25 February 2019

HONEYSUCKLE DRIVE (LOCAL ROAD): SSD 8999 – RESPONSE TO SUBMISSIONS, TWO EIGHT-STOREY MIXED USE BUILDINGS AND ONE SINGLE-STOREY RETAIL BUILDING CONTAINING GROUND FLOOR RETAIL PREMISES, 92 RESIDENTIAL APARTMENTS, TWO BASEMENT LEVELS OF PARKING CONTAINING 190 SPACES, PT LOT: 2000 DP: 1145678, 35 HONEYSUCKLE DRIVE, NEWCASTLE

Drawing Name
Site Plan / Site Analysis

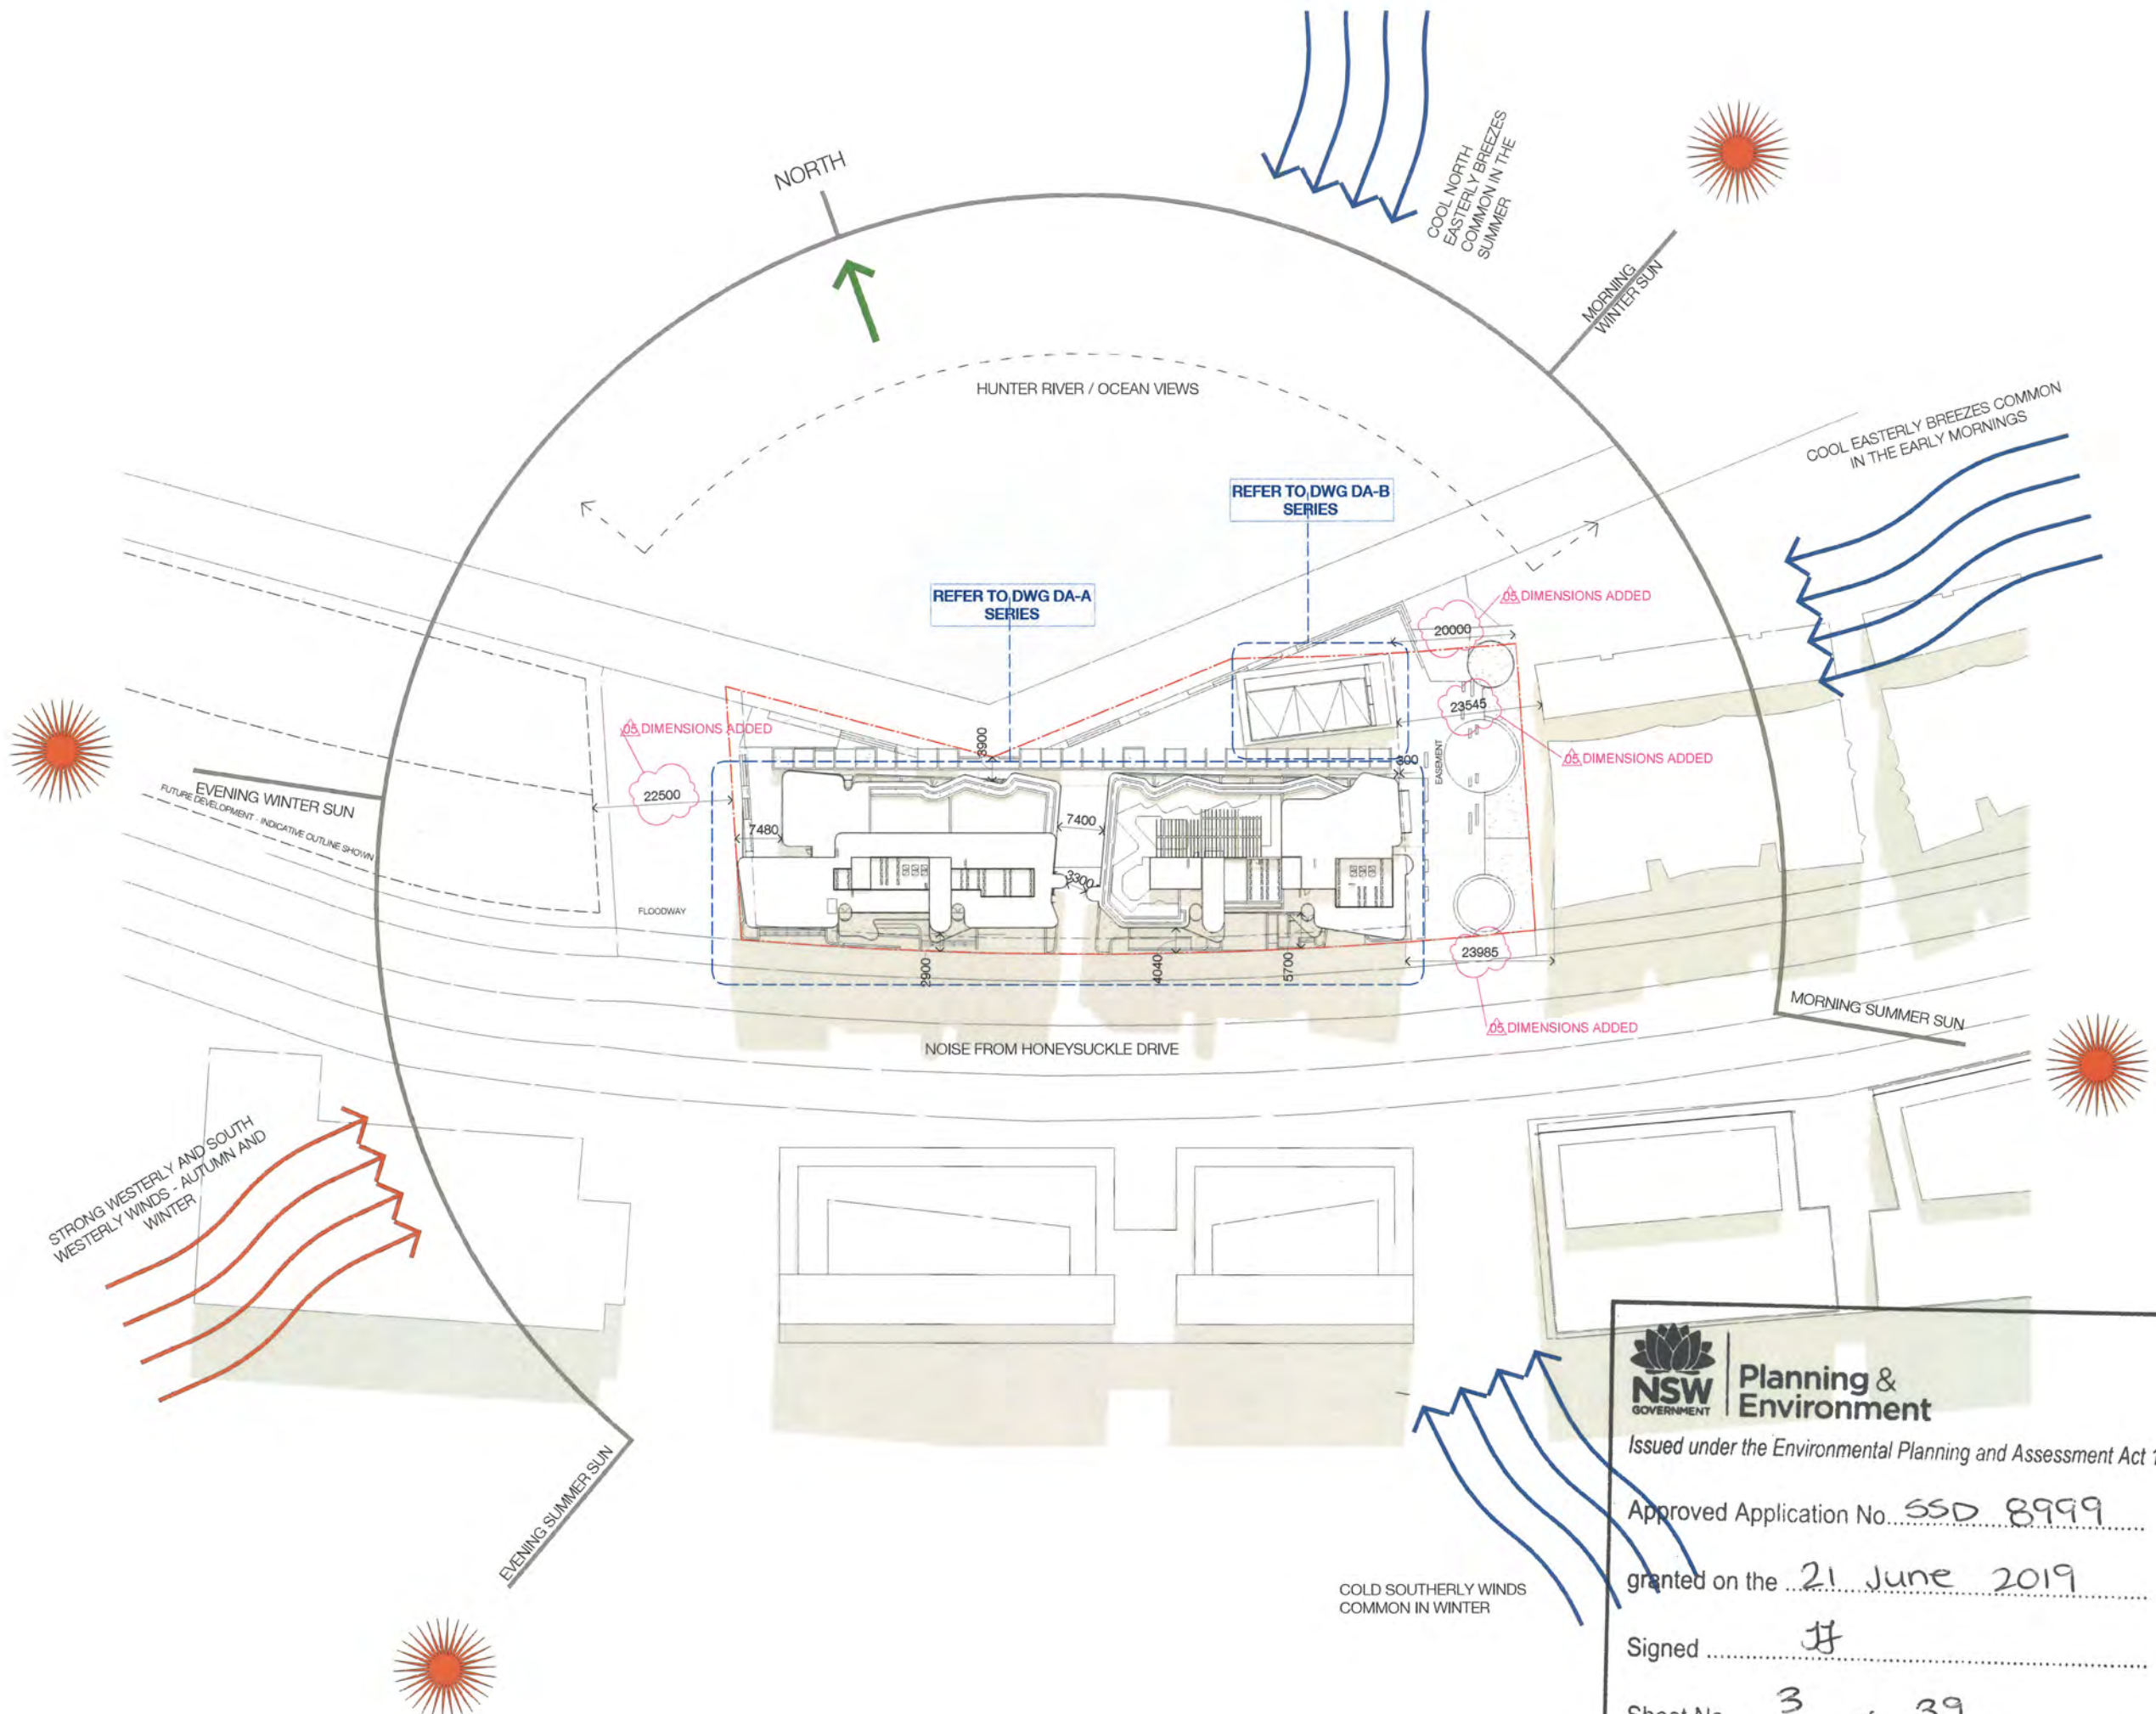
The proposed direct access from Honeysuckle Drive is undesirable for all road users (including pedestrians) particularly when the opportunity exists for the provision of a signalised side access road which can improve management of traffic flows and the overall efficiency of the road network.

This advice was also provided to the Department during the request for SEARs on 10 January 2019. Reviewing the Response to Submissions, it appears that the option has not been pursued. It is also noted that Council have not raised this as an option within their correspondence. Accordingly, Roads and Maritime have no further comments in relation to this proposal.

- Council should have consideration for appropriate sight line distances in accordance with the relevant Australian Standards (i.e. AS2890:1:2004) and should be satisfied that the location of the proposed driveway promotes safe vehicle movements.
